COMMUNITY SERVICES DEPARTMENT

Subject: Carriage Meadows South at Lorson Ranch Final Plat (PUDSP-16-002)

The Planning Division of the Community Services Department has reviewed the development application for Carriage Meadows South at Lorson Ranch Final Plat and has the following comments of behalf of El Paso County Parks. The original Carriage Meadows South at Lorson Ranch PUD Development Plan and Preliminary Plan was previously considered by the Park Advisory Board on August 10, 2016 and endorsed the following recommendation:

CARRIAGE MEADOWS SOUTH AT LORSON RANCH

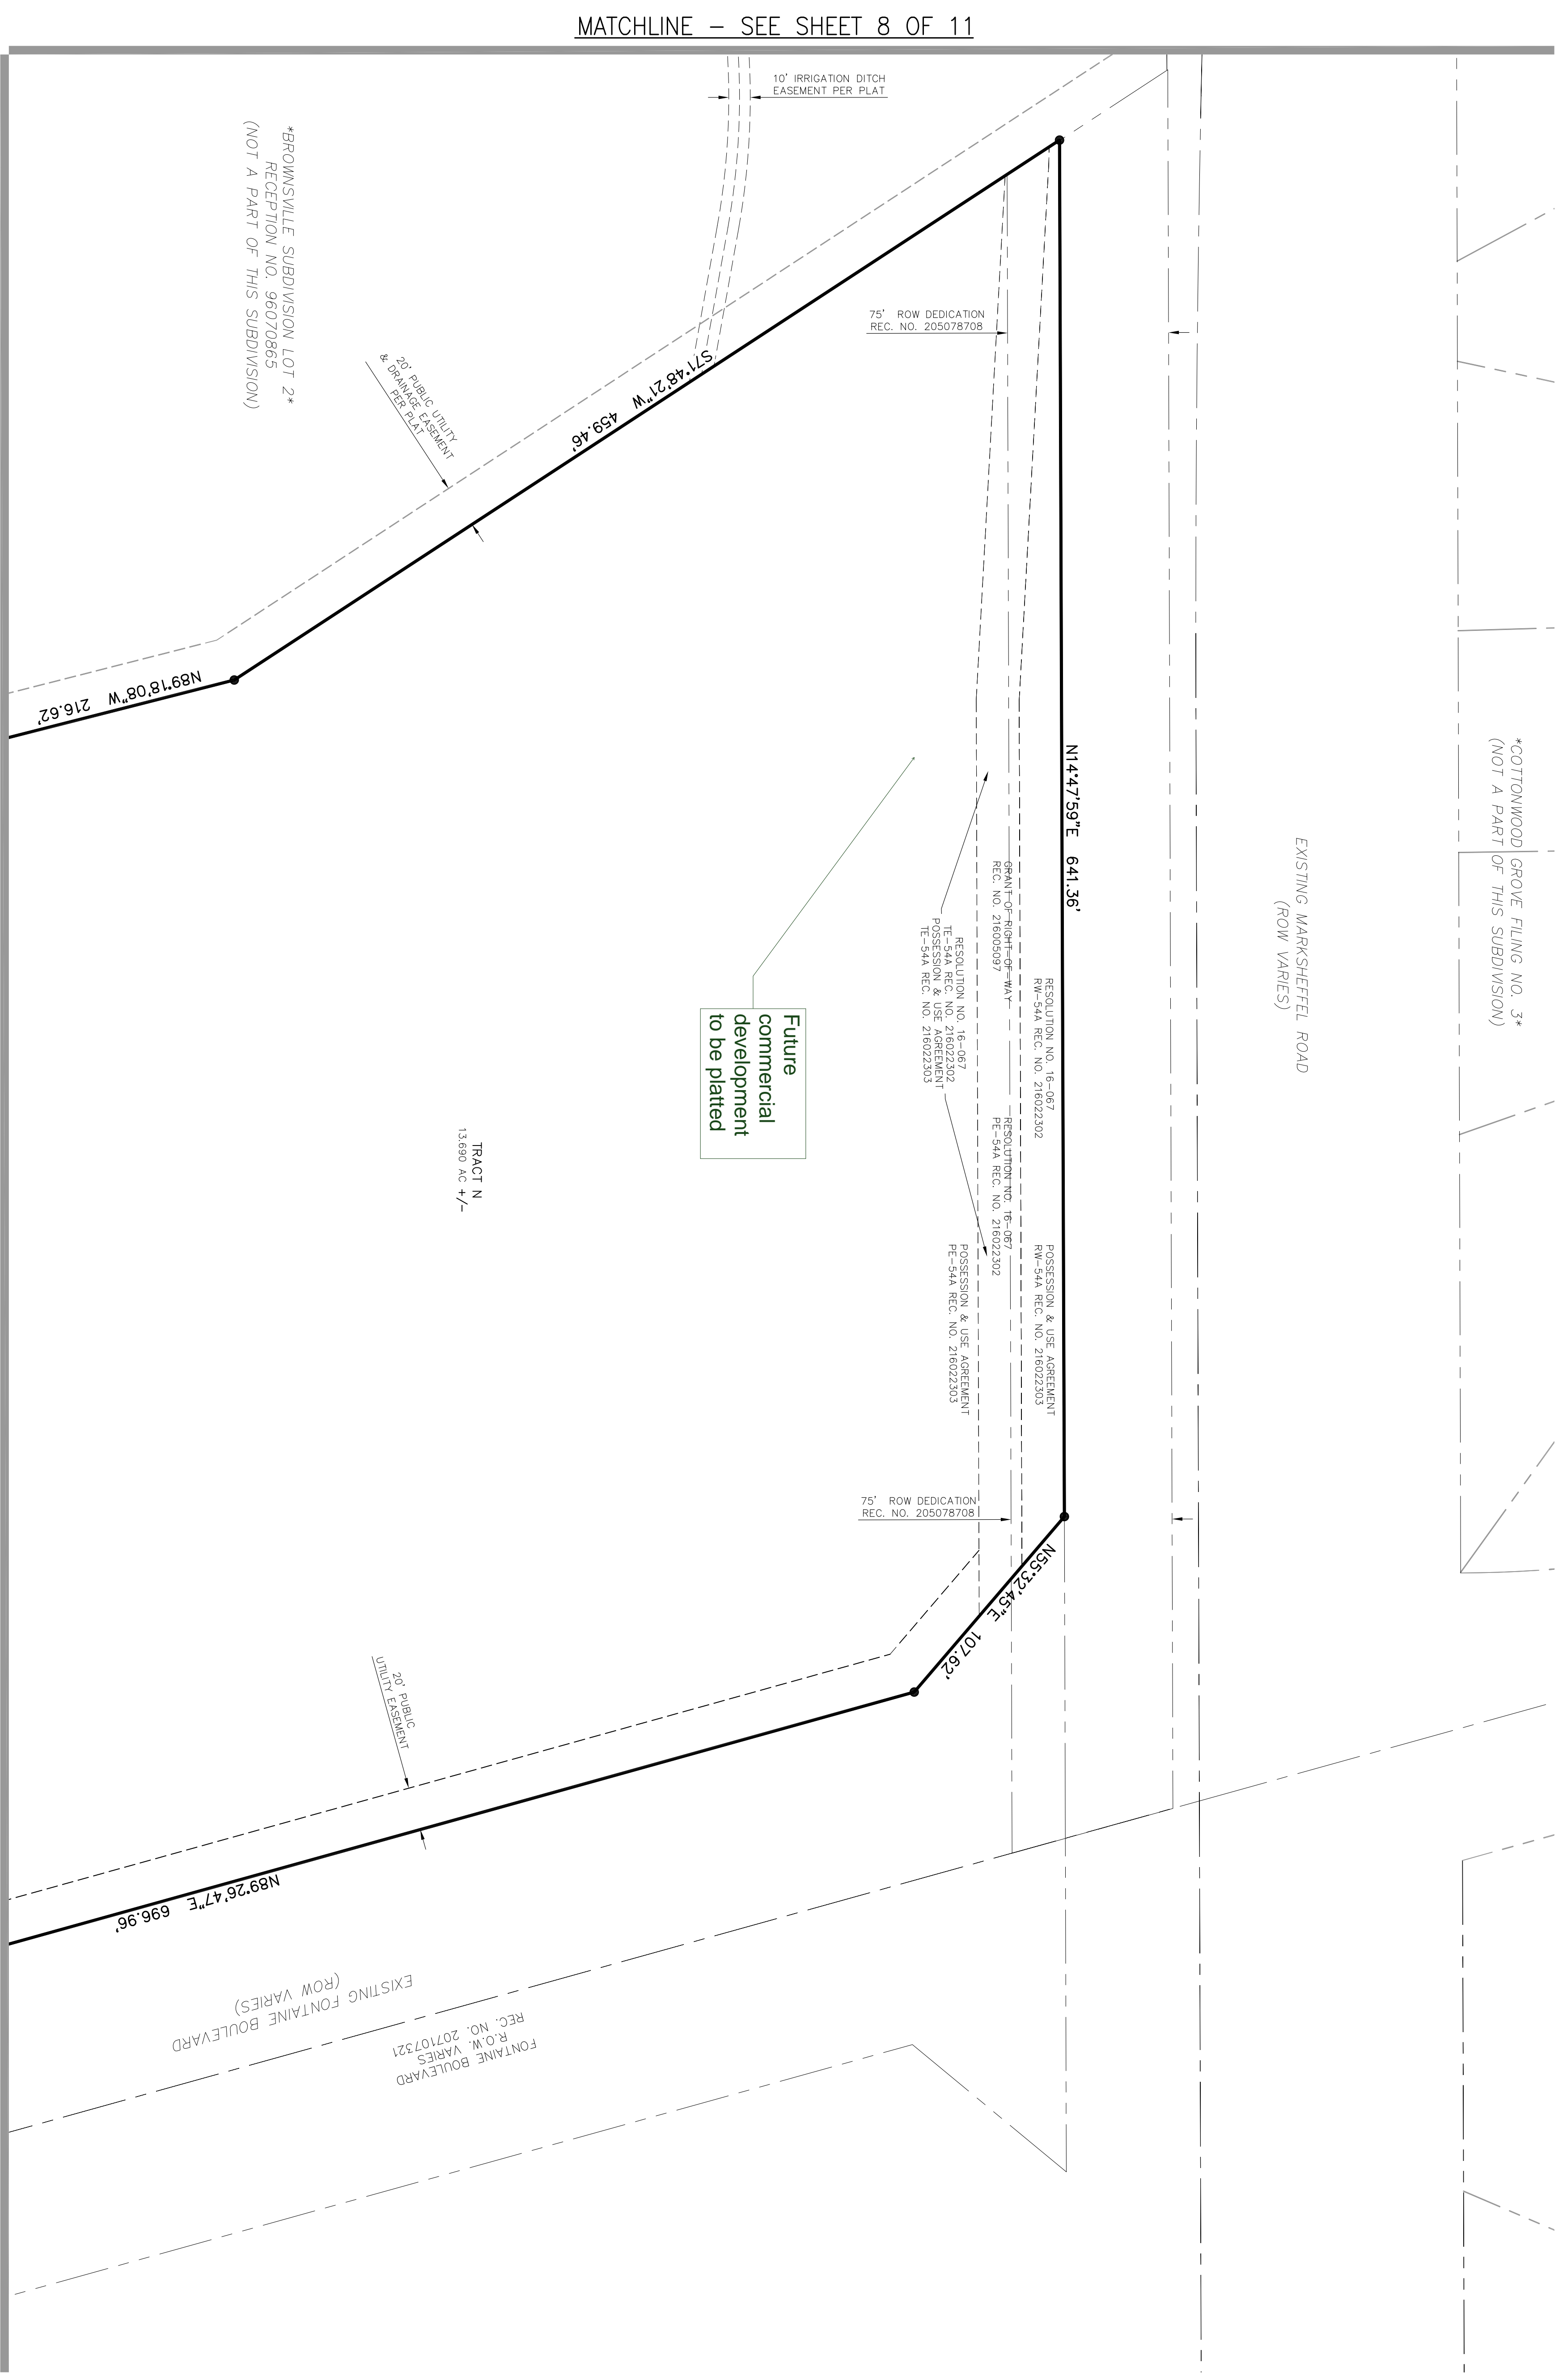
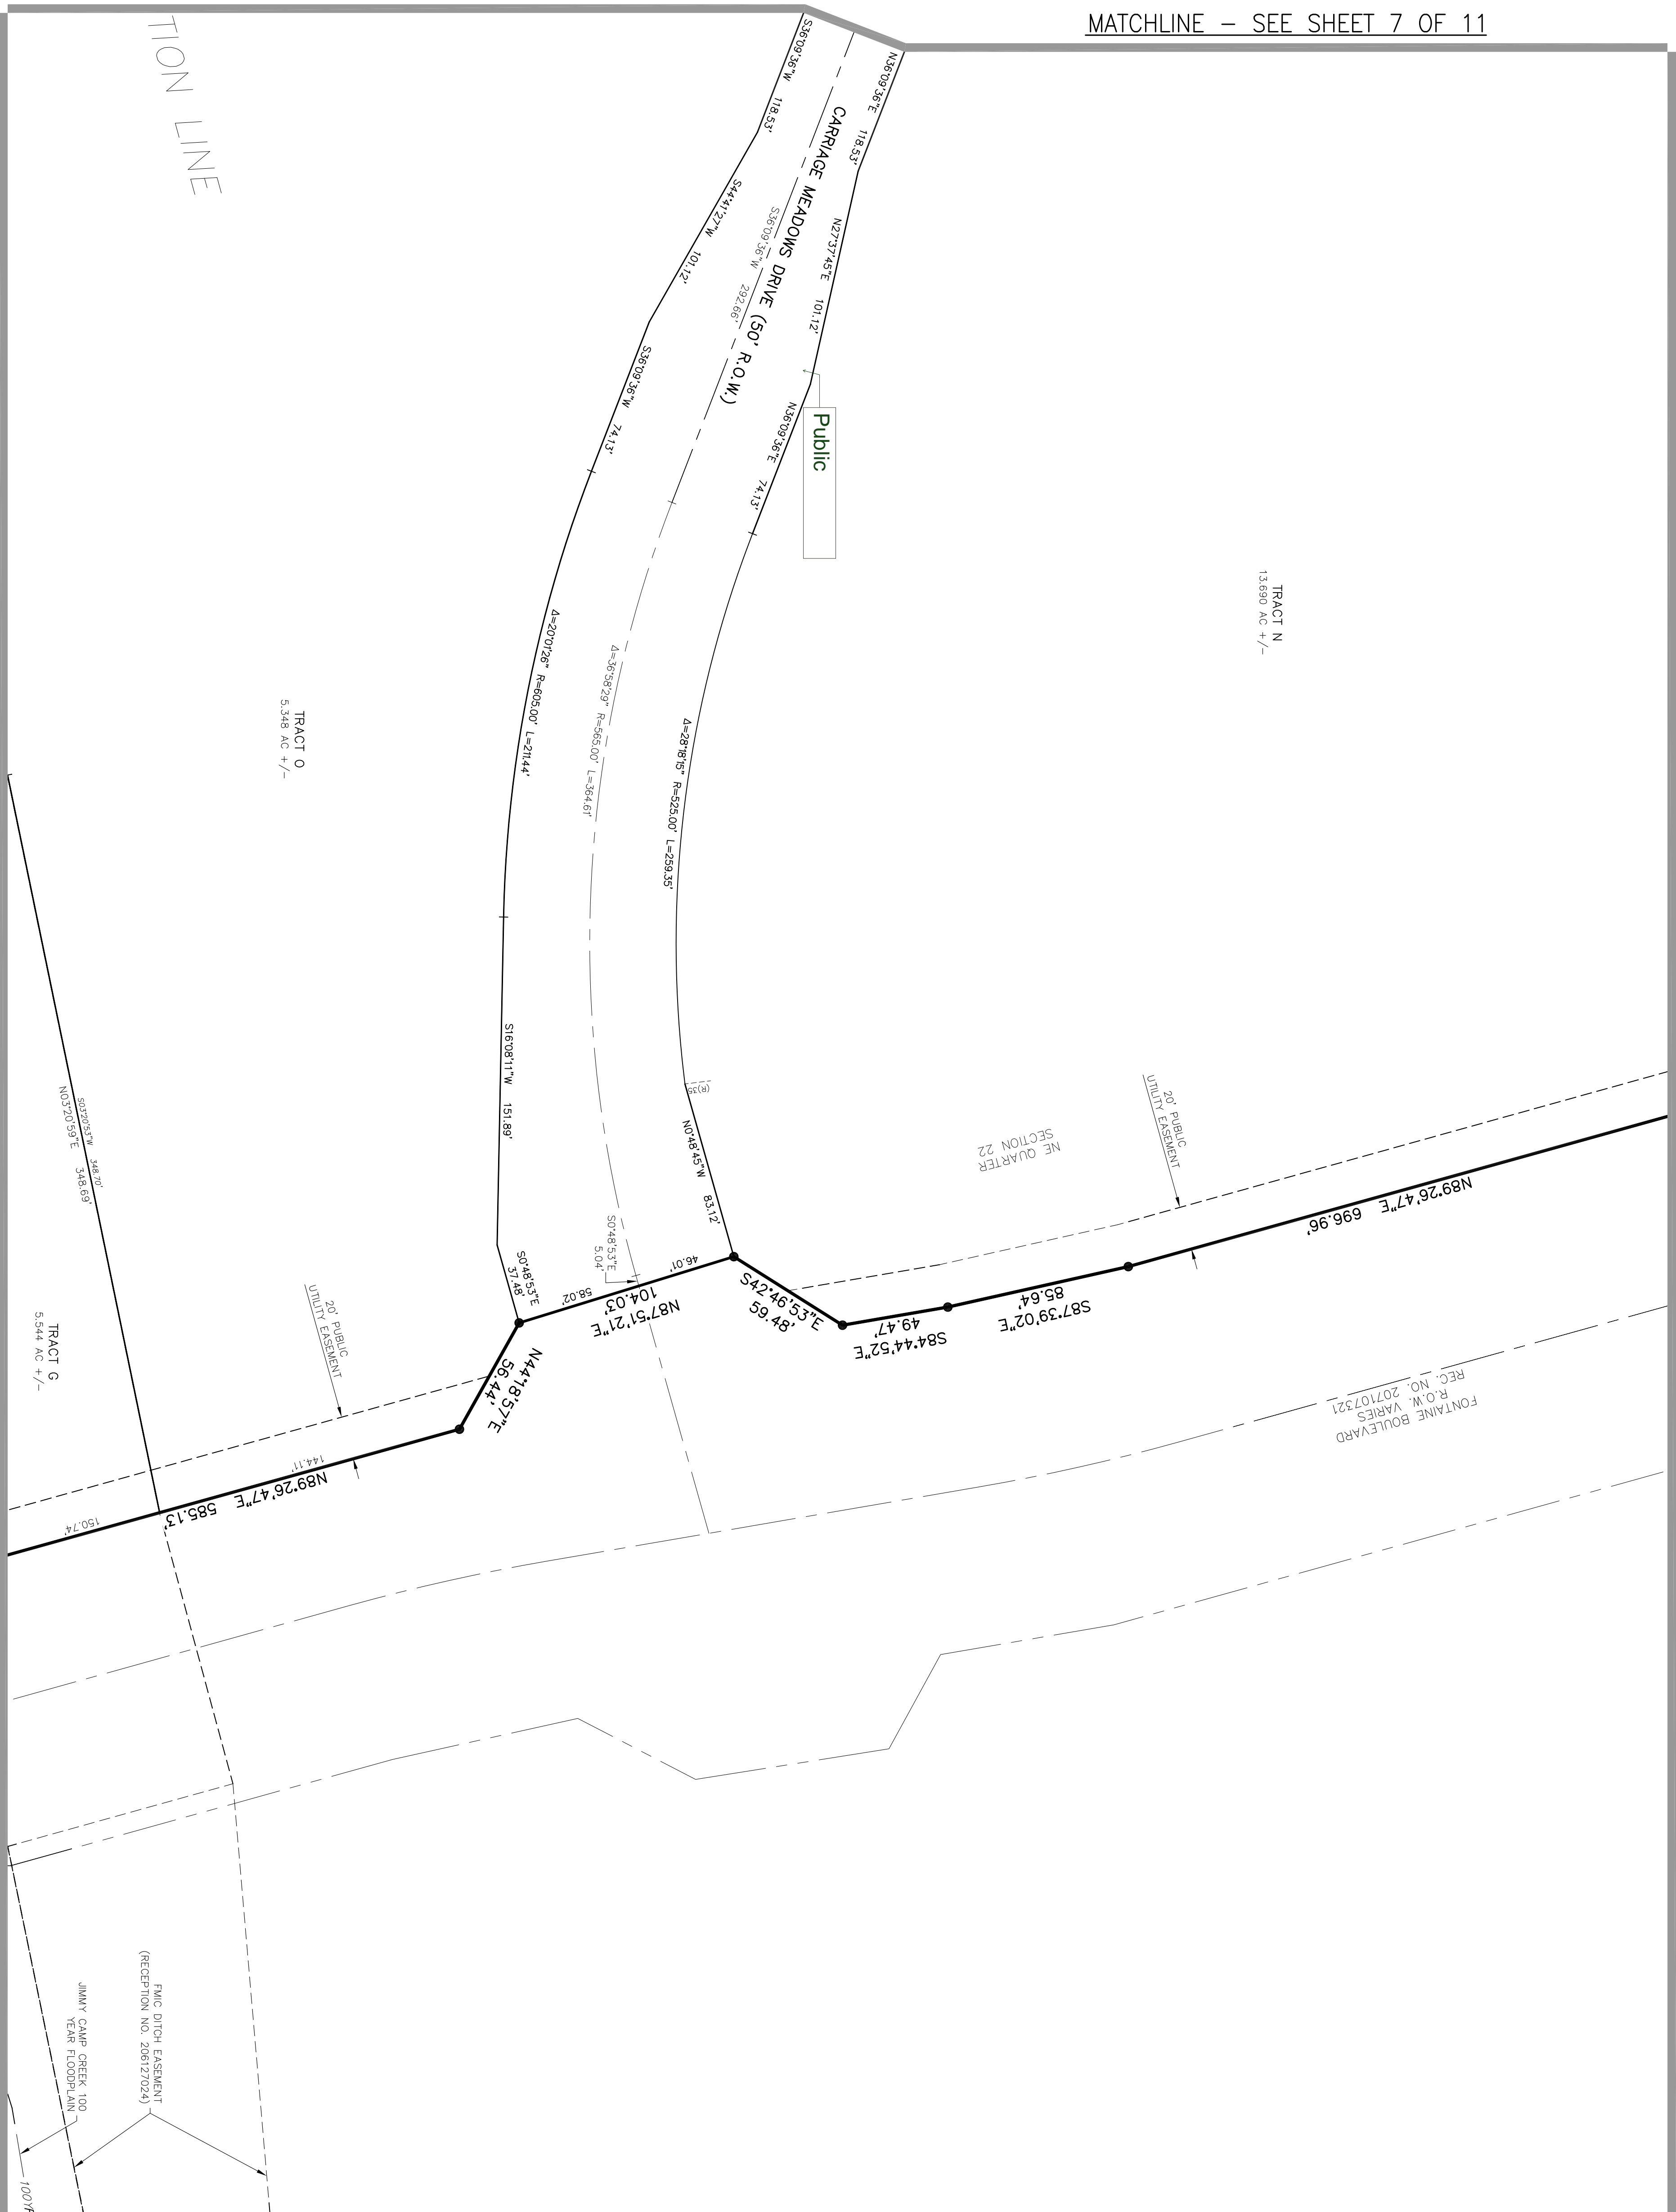
The El Paso County Parks Master Plan shows the Jimmy Camp Creek Primary Regional Trail running along the eastern edge of Jimmy Camp Creek within the project area. The previously approved PUD/Preliminary Plan drawings show the regional trail but it is not shown on the Final Plat drawings. Therefore, Park staff recommends

that Final Plat drawings show the regional trail along the eastern edge of Jimmy Camp Creek, and dedication of the 25-foot wide regional trail easement within Tract E and F to the County for regional trail purposes.

Recommend to the Planning Commission and Board of County Commissioners that approval of Carriage Meadows South at Lorson Ranch Final Plat include the following conditions: (1) A 25-foot wide public trail easement shall be provided and shown on the final plat for a Regional Trail along the eastern edge of Jimmy Camp Creek; (2) Require fees in lieu of land dedication for regional park purposes in the amount of \$95,645 and urban fees in the amount of \$60,395.
